From: Martyn White
Sent: 31 August 2018 11:23
To: Planning.Responses
Subject: AW/177/18/HH

AW/177/18/HH

The proposed works are varied and include provision of render, a roof light and solar panels.

DATE/DRAWN BY:	27/04/18 Drawn by JS
CLIENT:	Mike & Alison Terry
PROJECT:	28 The Drive, Aldwick
SCALE:	1:100@A3
DRAWING TITLE:	WEST ELEVATION

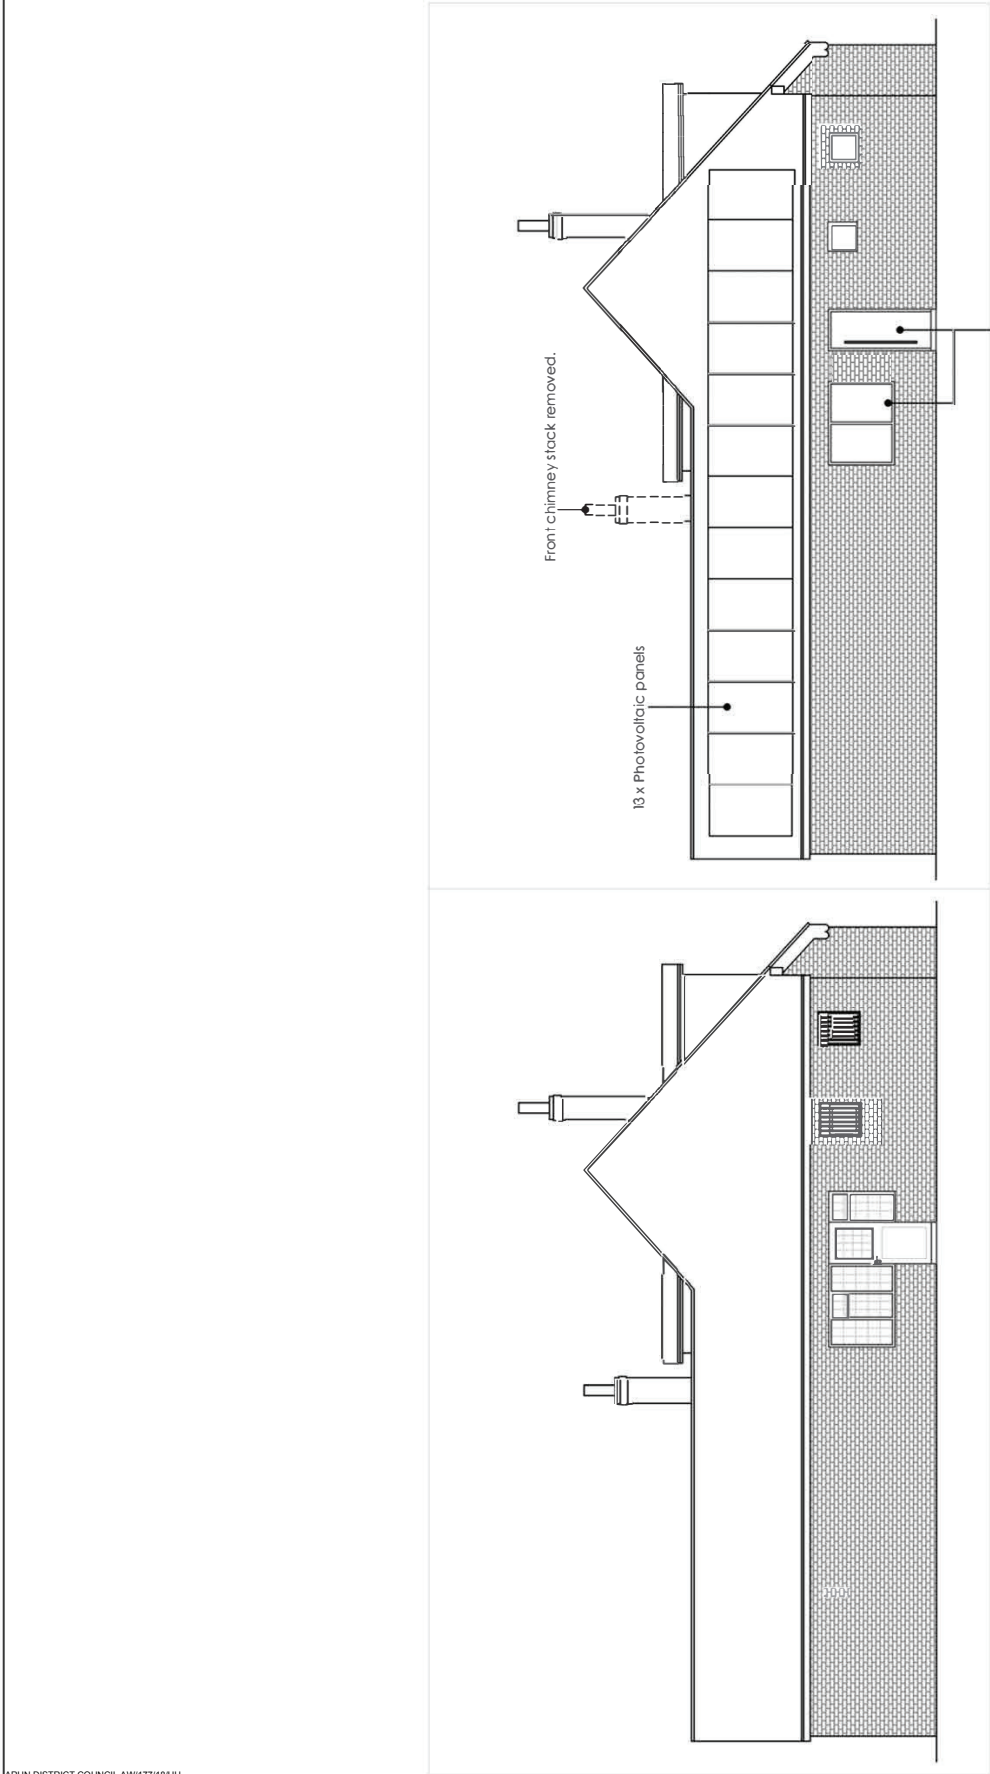
The installation of the solar panels would result in a significant area of the roof on one elevation being covered with renewables. However, it is considered that very little of it will be visible from the public domain, and as a consequence will have a neutral impact upon the character and appearance of the conservation area.

The majority of the works proposed appear to be acceptable; it is considered that the use of render on certain elevations will help to harmonise the use of materials found within the building, and can be supported. Other works, such as the roof lights will have a neutral impact upon the building, when read as a whole.

However, there are some concerns regarding the chimney. The loss of the chimney is unfortunate, as it appears to be on the oldest part of the building, and would result in the loss of historic fabric. No information has been provided to state why the chimney should be removed; is it related to concerns of a structural nature?
